Arun District Council
Arun Civic Centre
Maltravers Road
Littlehampton
West Sussex BN17 5LF
Planning General Enquiries
Tel: (01903) 737756 Fax: (01903) 730442
Dx: 57406 Littlehampton
Minicom: 01903 732765
e-mail: planning@arun.gov.uk
website: www.arun.gov.uk/planning

Town & Country Planning Act 1990 (as amended)
Town and Country Planning (Development Management Procedure) (England) Order 2015
Approval of details reserved by condition imposed under ref WA/69/17/PL relating to Condition No
3,4,5,7,8,9
Progress Garage Yapton Lane, Walberton,

Arun District Council have decided to **REFUSE** details reserved by condition for the following reasons:

DRAWING TITLE
Site Plan

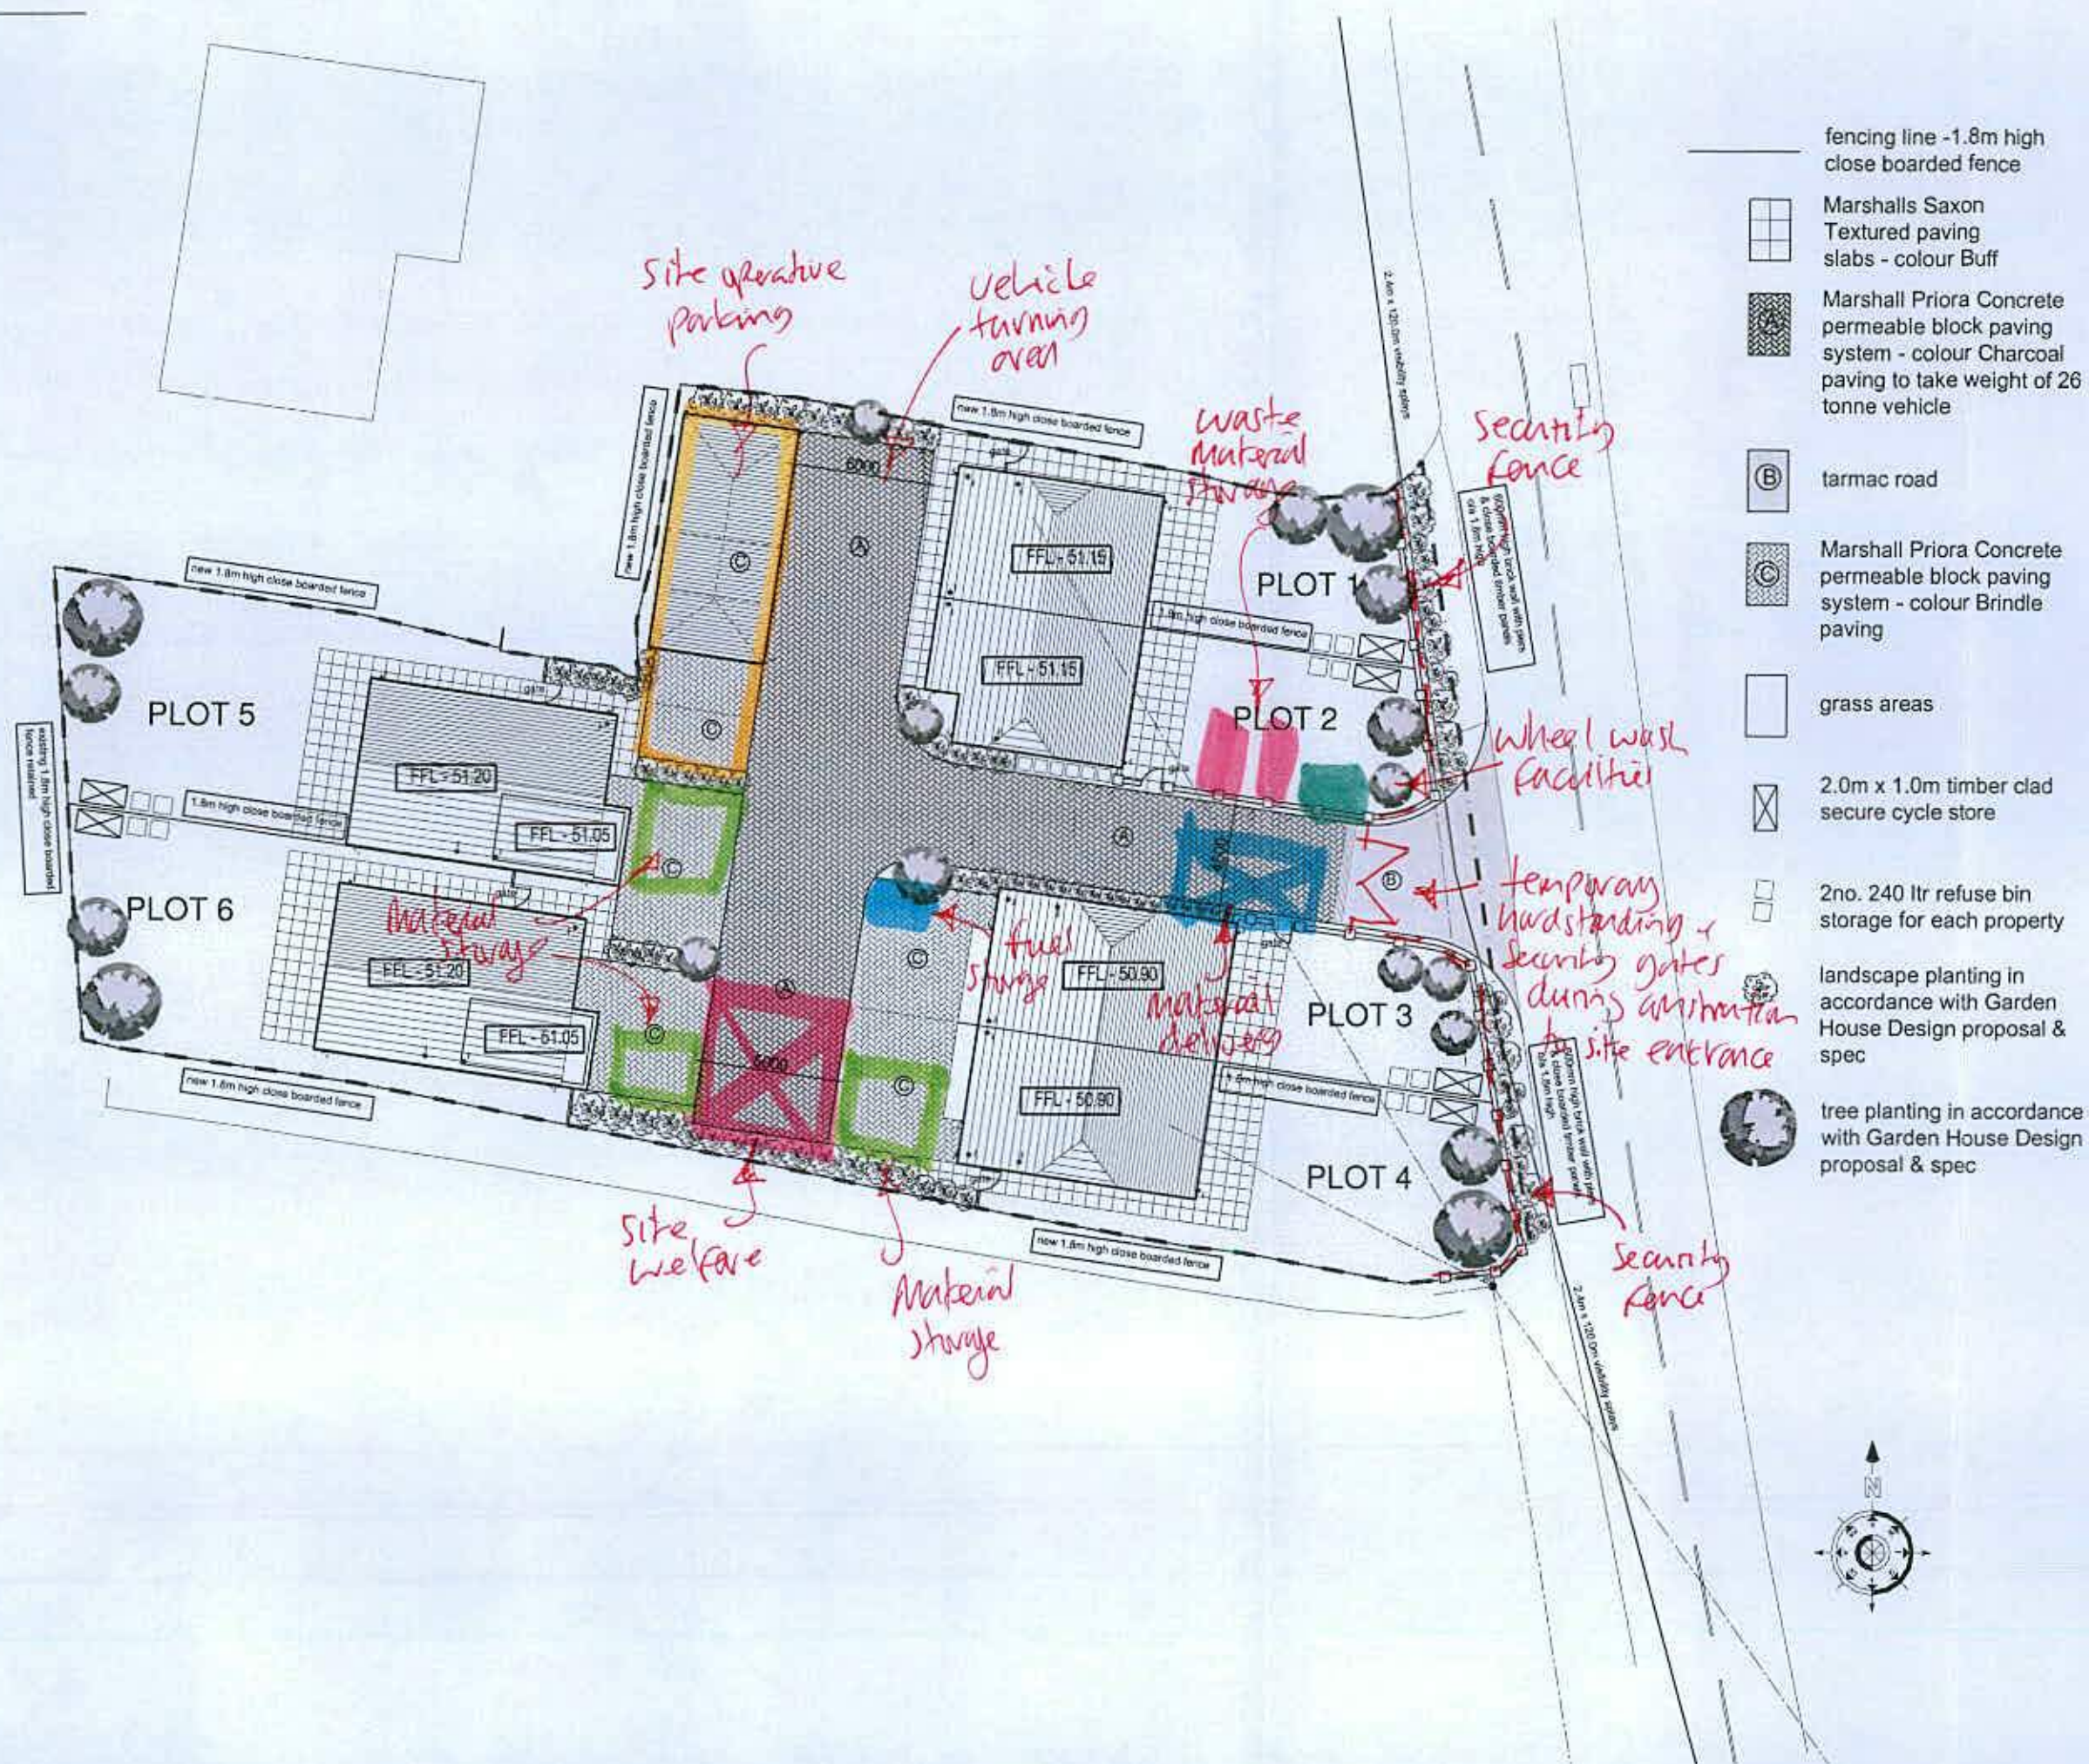
This condition cannot be discharged without additional clarification outlining that a delivery vehicle could turn within the site to exit onto Yapton Lane in a forward gear. Although it is stated that best efforts will be taken to ensure that smaller vehicles are used, the possibility that a larger HGV may enter the site is still a viable consideration. Although it is appreciated that a swept path was submitted at planning, this had not included details of the positioning of the welfare building within the roadway which restricts some of the space during construction.. Should this manoeuvre not be achievable-you should ensure that a banksman is available within the site at all times to assist in the manoeuvring of vehicles onto the highway. Such details must included within the submitted CMP..

It is advised that deliveries are scheduled to be outside of the am and pm network peak times to avoid congestion on the highway and this should be included in the CMP.
